To: South Holland District Council Application Ref: H06-1292-25

Proposal: **Erection of Agricultural Dwelling - outline approval H06-0101-24**

Location: **Land at Green Lane, Holbech St Johns, Spalding**

ADDITIONAL INFORMATION REQUIRED

Site Plan
Scale: 1:200

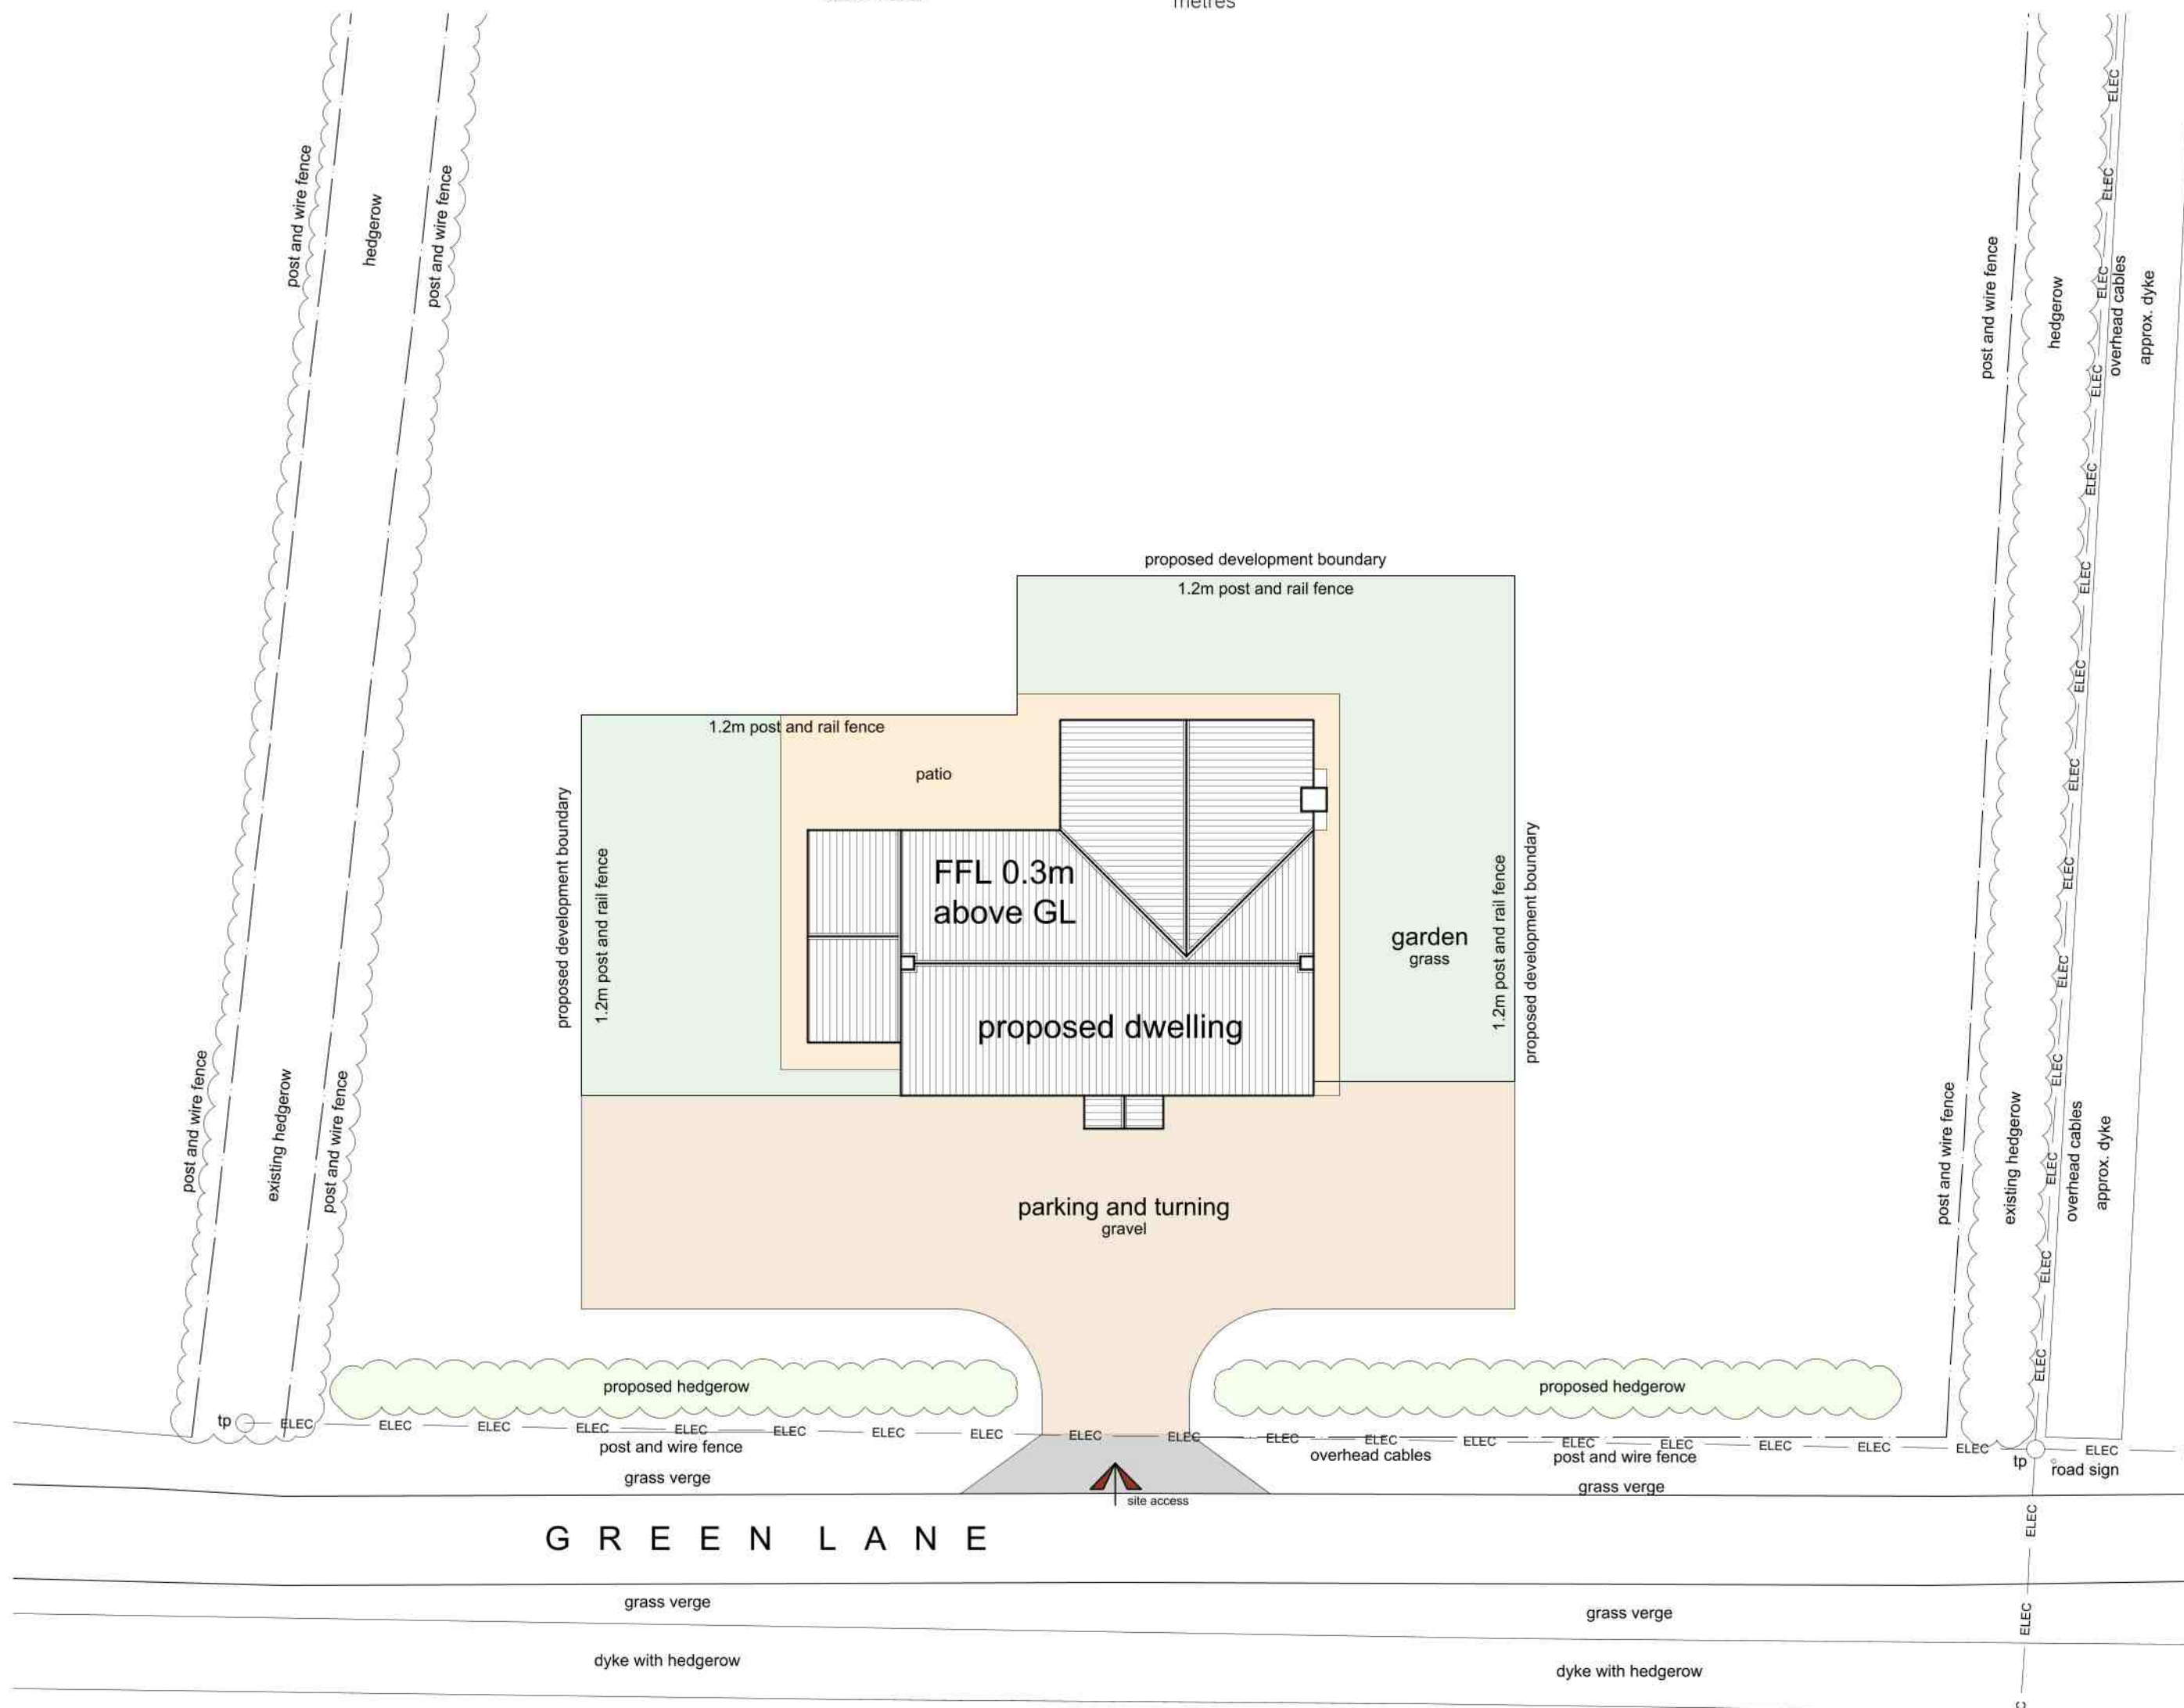
A note needs to be added to the proposed site plan to say that the access will be constructed to Lincolnshire County Council Specification.
